Comments on Planning Application 2023/61/93714/E

[2023/61/93714/E](#)

Land off, Cumberworth Lane, Denby Dale, Huddersfield, HD8 8RU

Reserved Matters application (including the consideration of access, appearance, landscaping layout, and scale) for the erection of 10 dwellings pursuant to outline permission 2019/93906 for erection of residential development up to 10 dwellings, and discharge of condition 20 (waste arrangements)

Drawing:
Sections As Proposed

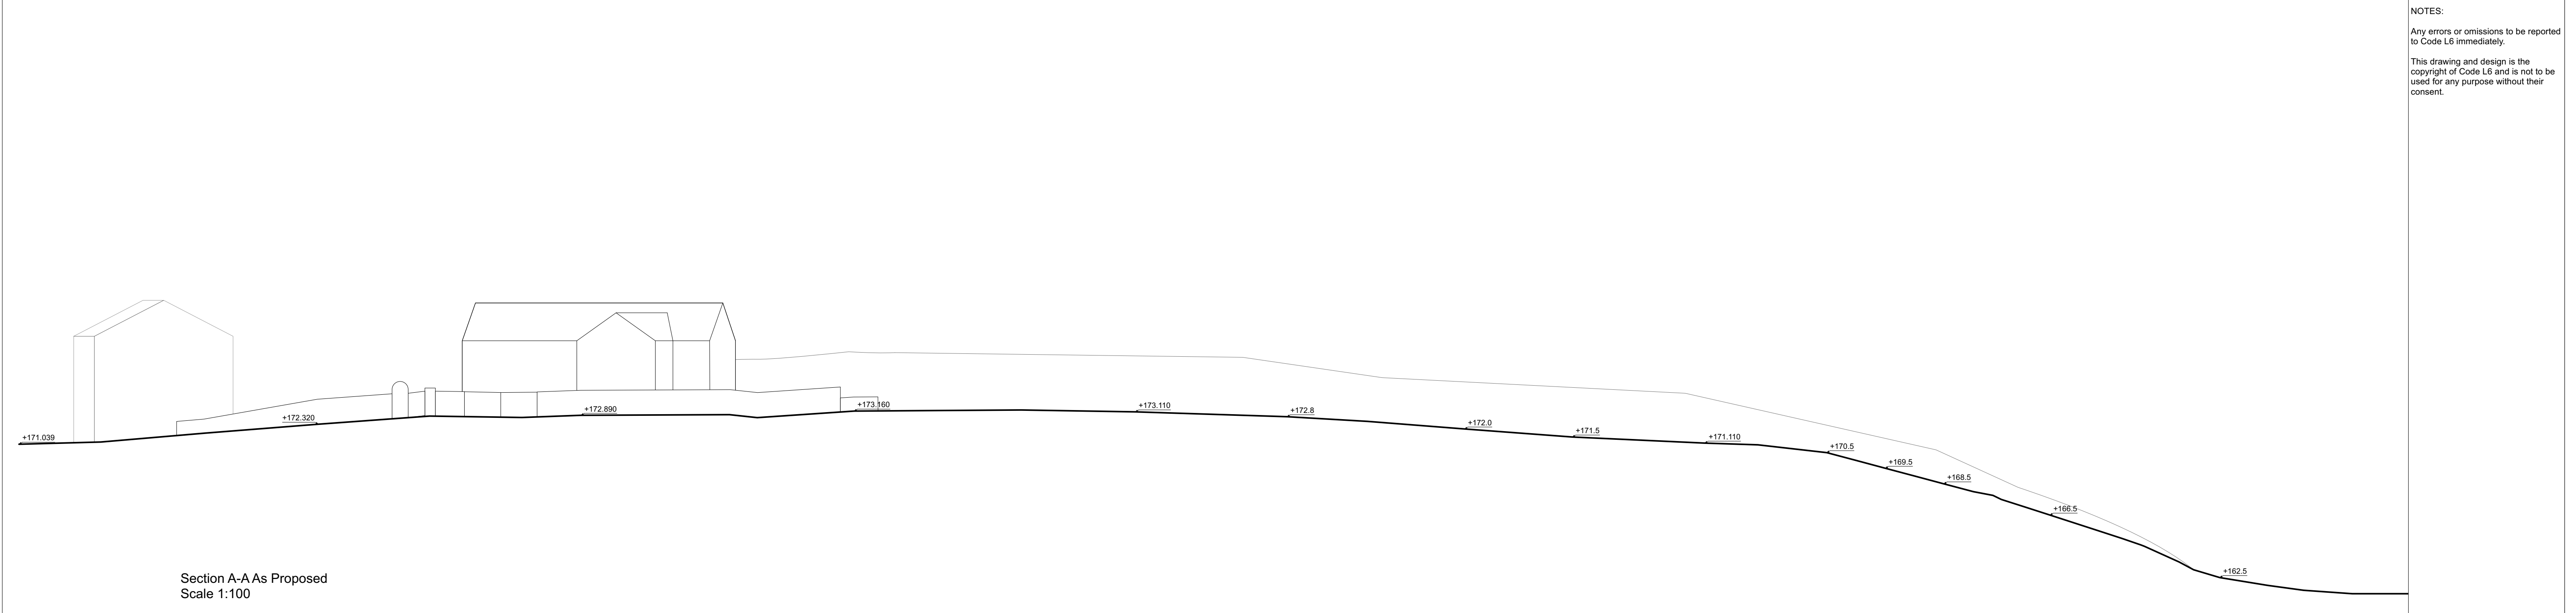
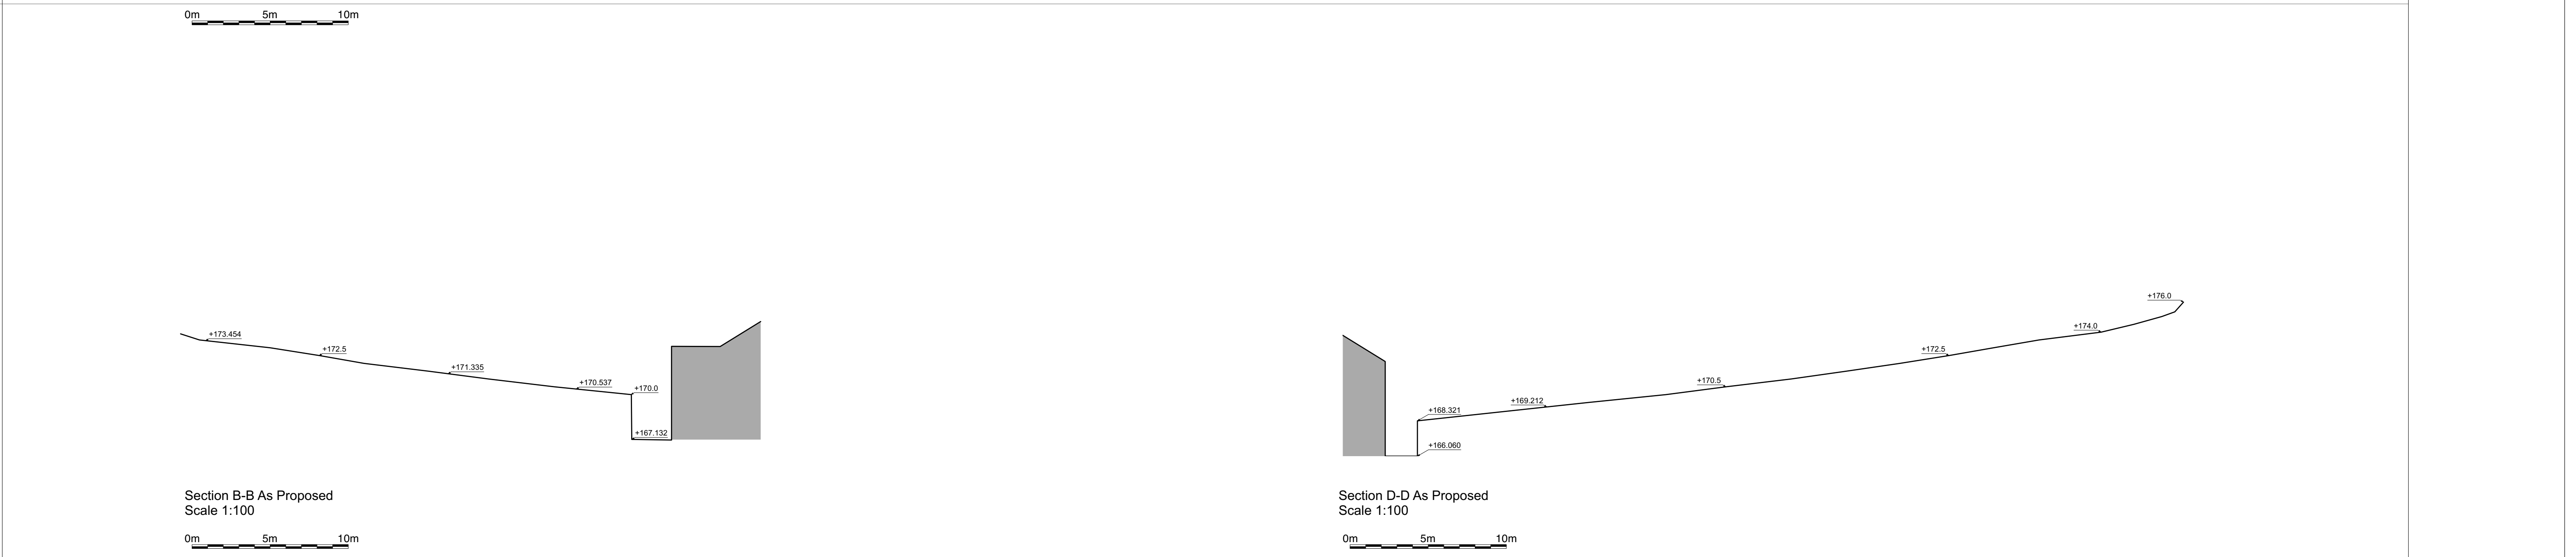
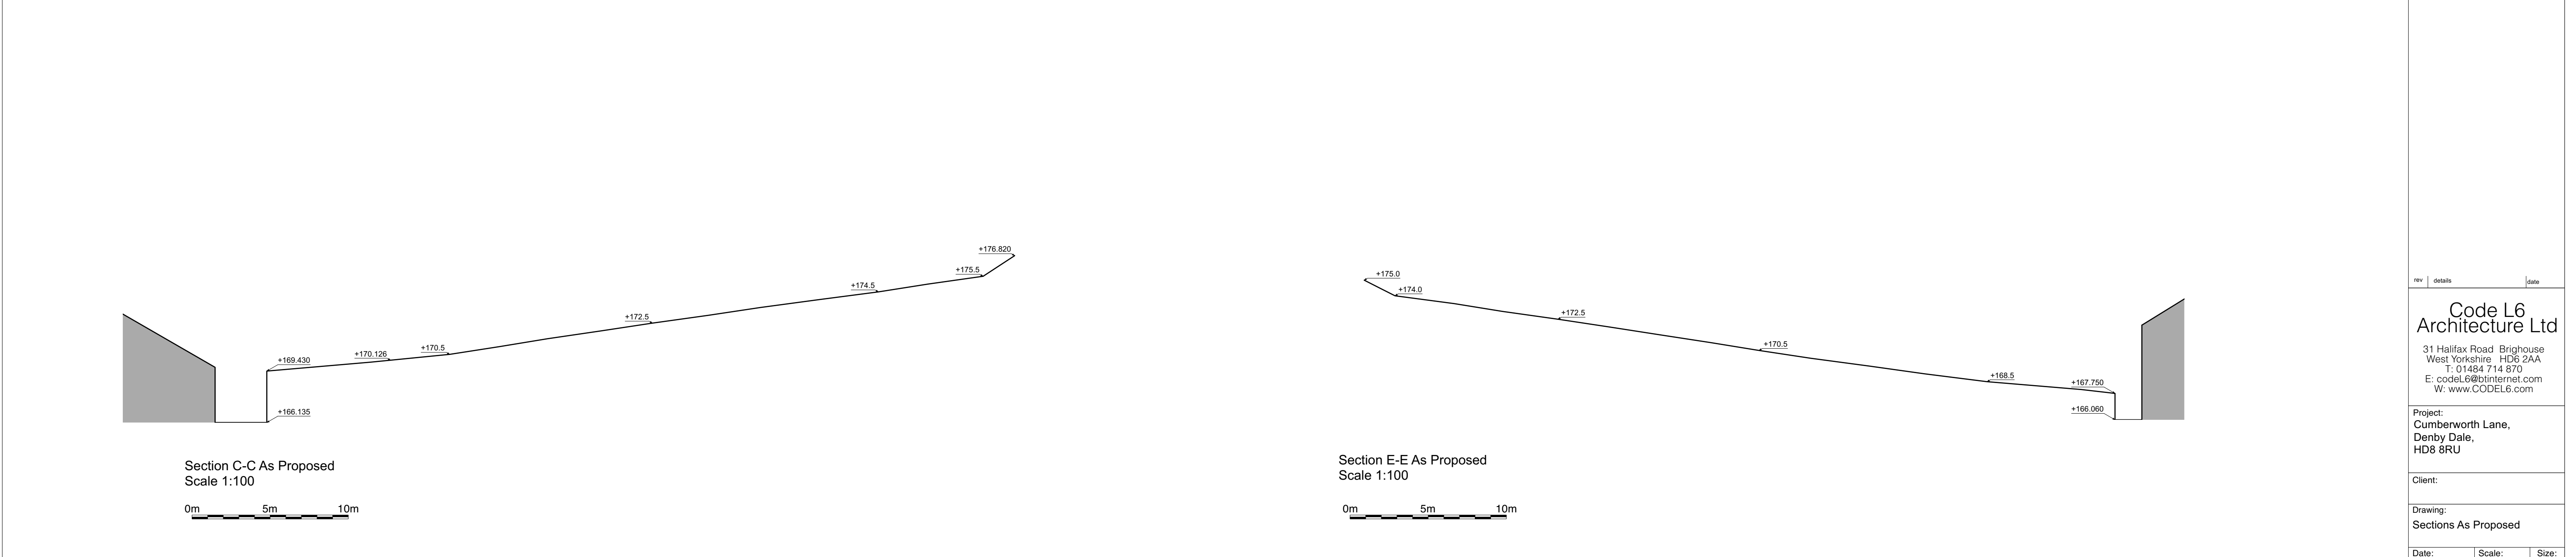
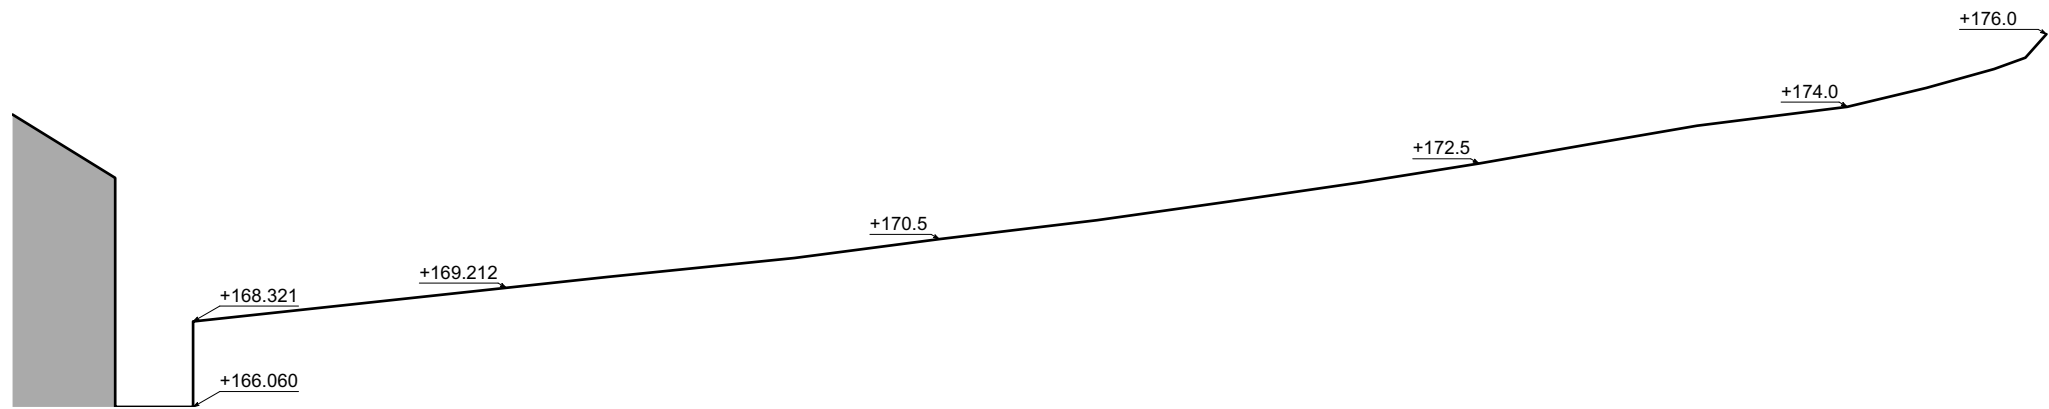
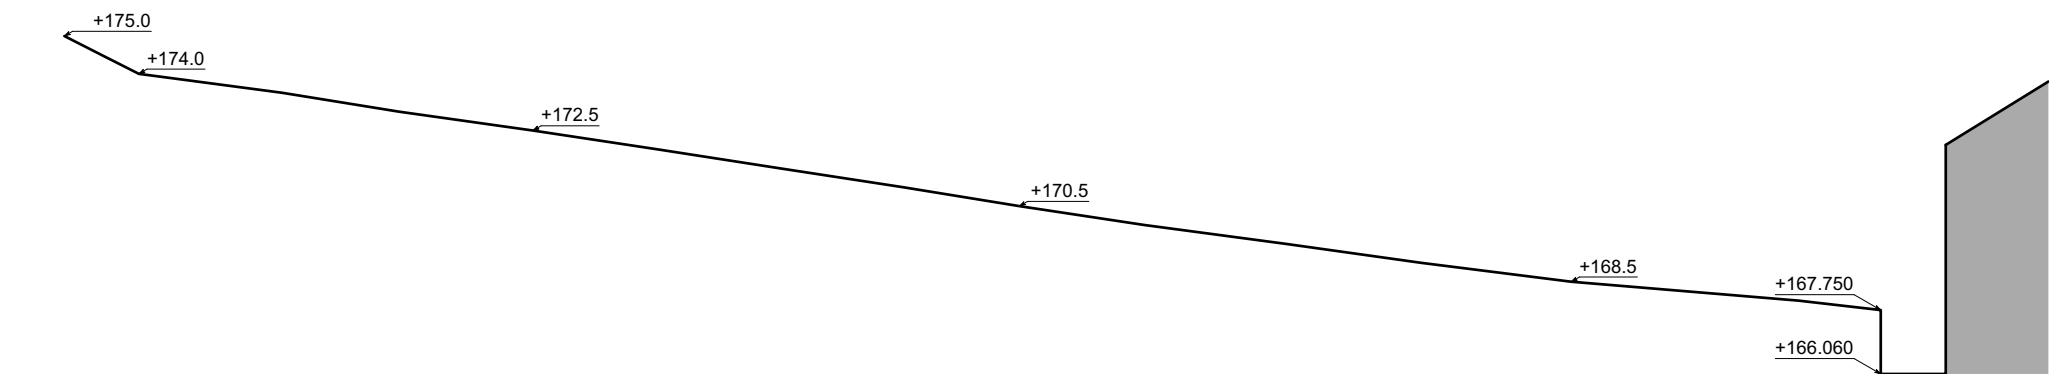
It appears that the ground elevation will be substantially lowered next to the garden fence of Cruck Cottage. How will the existing garden, fence and boundary be protected?

The existing ground elevation at the rear of Units 3 and 4 is approximately 175.4 m. With the base of these proposed properties given as 172.9 m, it appears that the ground immediately adjacent to the fence of Cruck Cottage would be excavated to 2.5 m depth (not including foundations).
